From: Adam King [REDACTED]
Sent: 16 September 2019 18:13
To: Zac Denton <Zac.Denton@arun.gov.uk>
Subject: RE: K/19/19/HH Little Tangle, Middle Way, Kingston Gorse

" K/19/19/HH Little Tangle, Kingston Gorse. The proposed development involves more than a simple extension to the existing property. The proposal involves raising the roof height to 15.4 metres creating a new dwelling level at first floor height and adding a balcony at that level. This would result in significant overlooking of the properties and gardens on either side of Little Tangle and there is no evidence in the application as to how this might be avoided or mitigated. Additionally, the proposal is to provide grey slate for the new roof and this would be out of keeping surrounding properties which are provided with clay tiles and/or Horsham stone and is therefore contrary to policy D DM1 (1) of the Arun Local Plan."

EXISTING  
ELEVATIONS

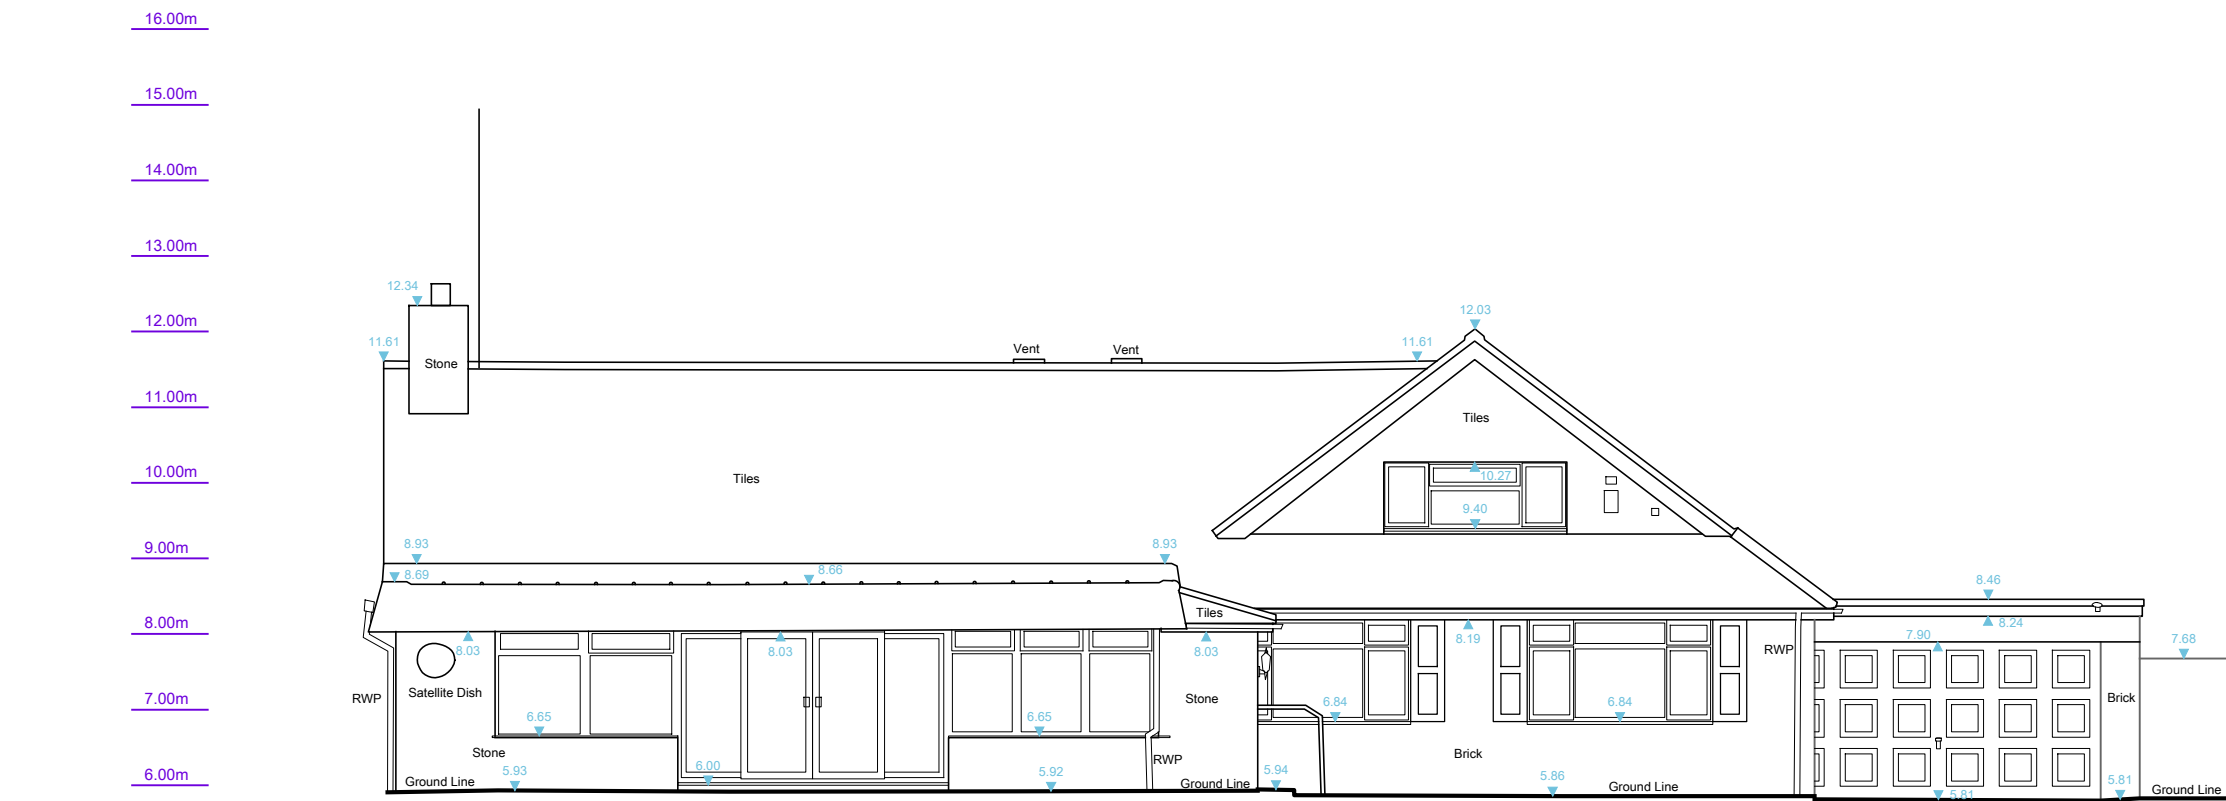
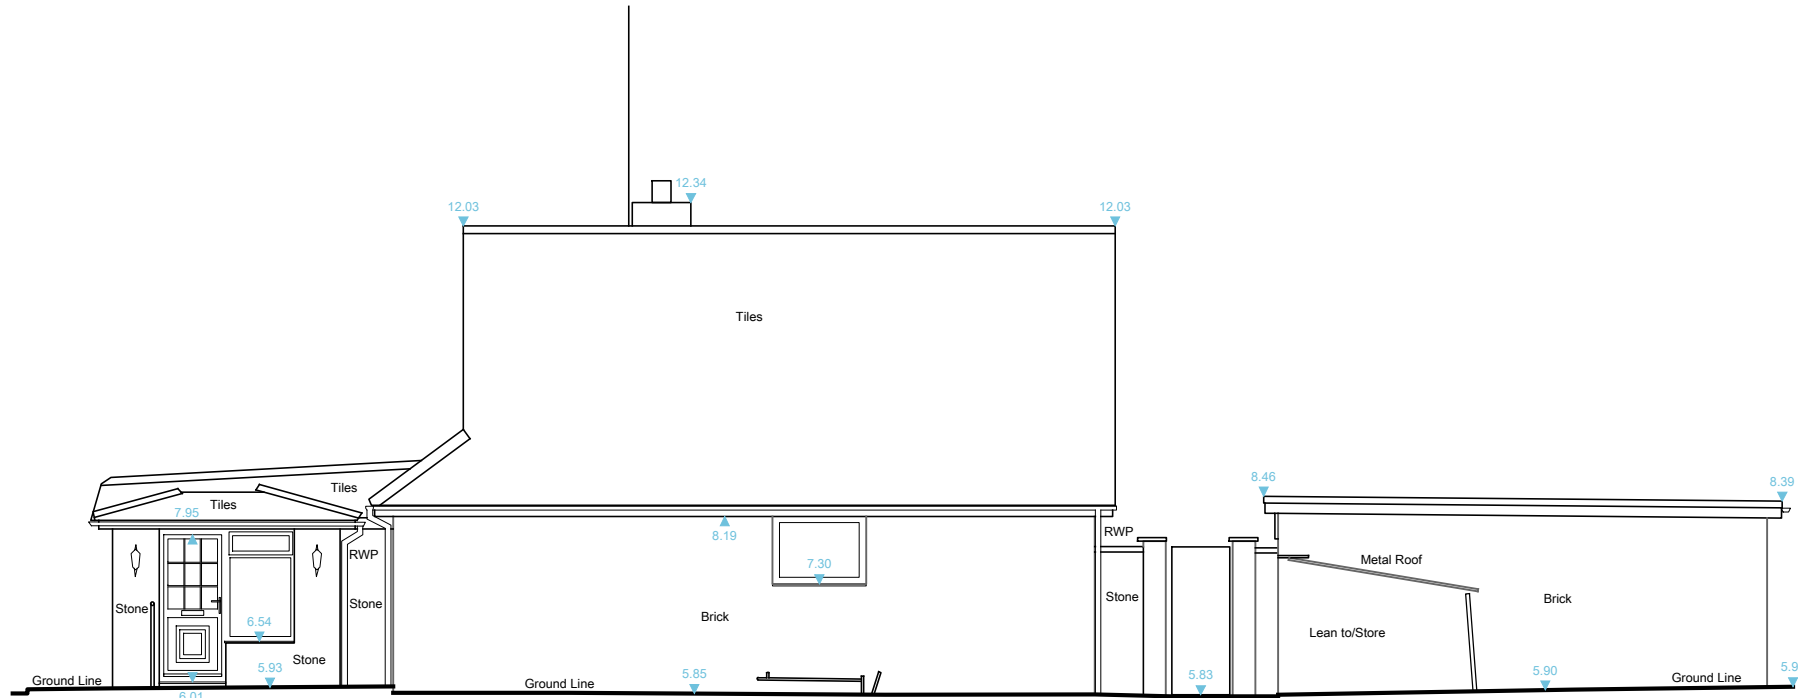
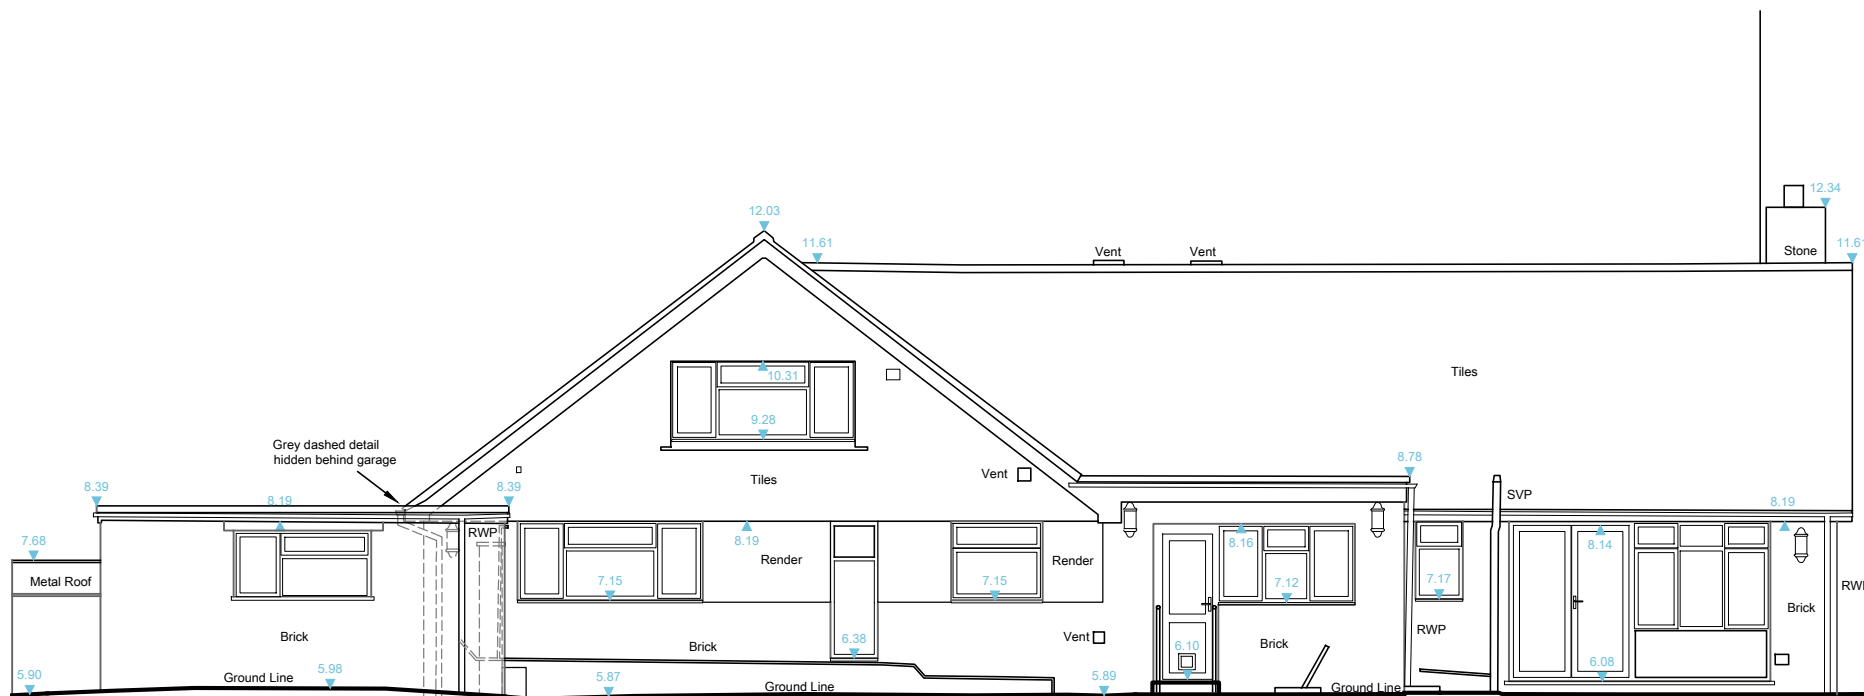
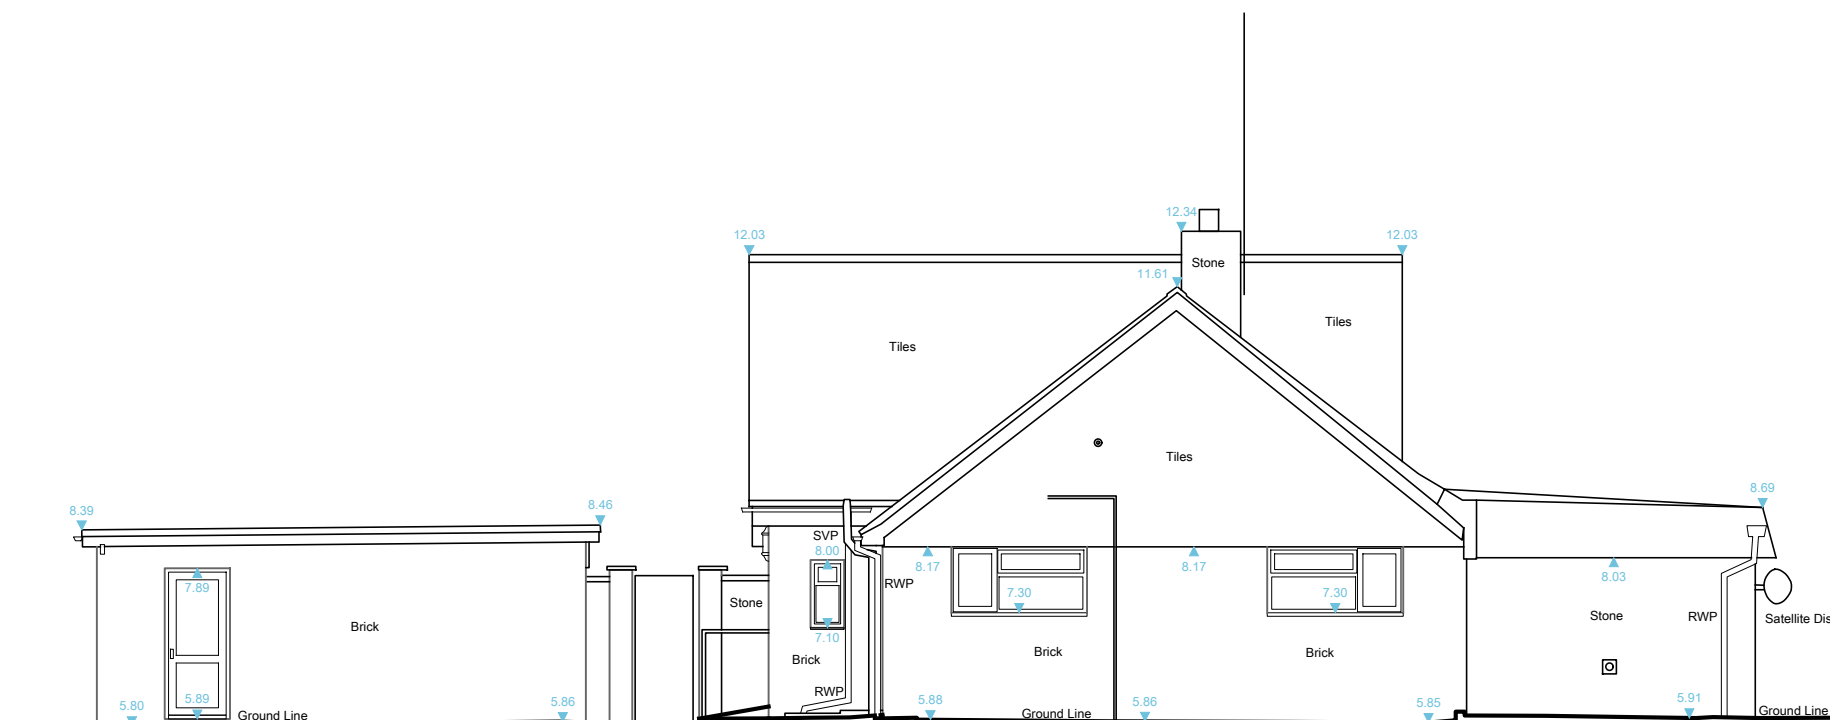
- Most importantly, the proposed ridge height is proposed as the same height as the neighbouring property Clova.
- The Cllr. also notes that there is a 'new dwelling level at first floor height'. As you know from the existing elevations submitted and from visiting site, the current house already has a first floor - copy of existing elevations attached.
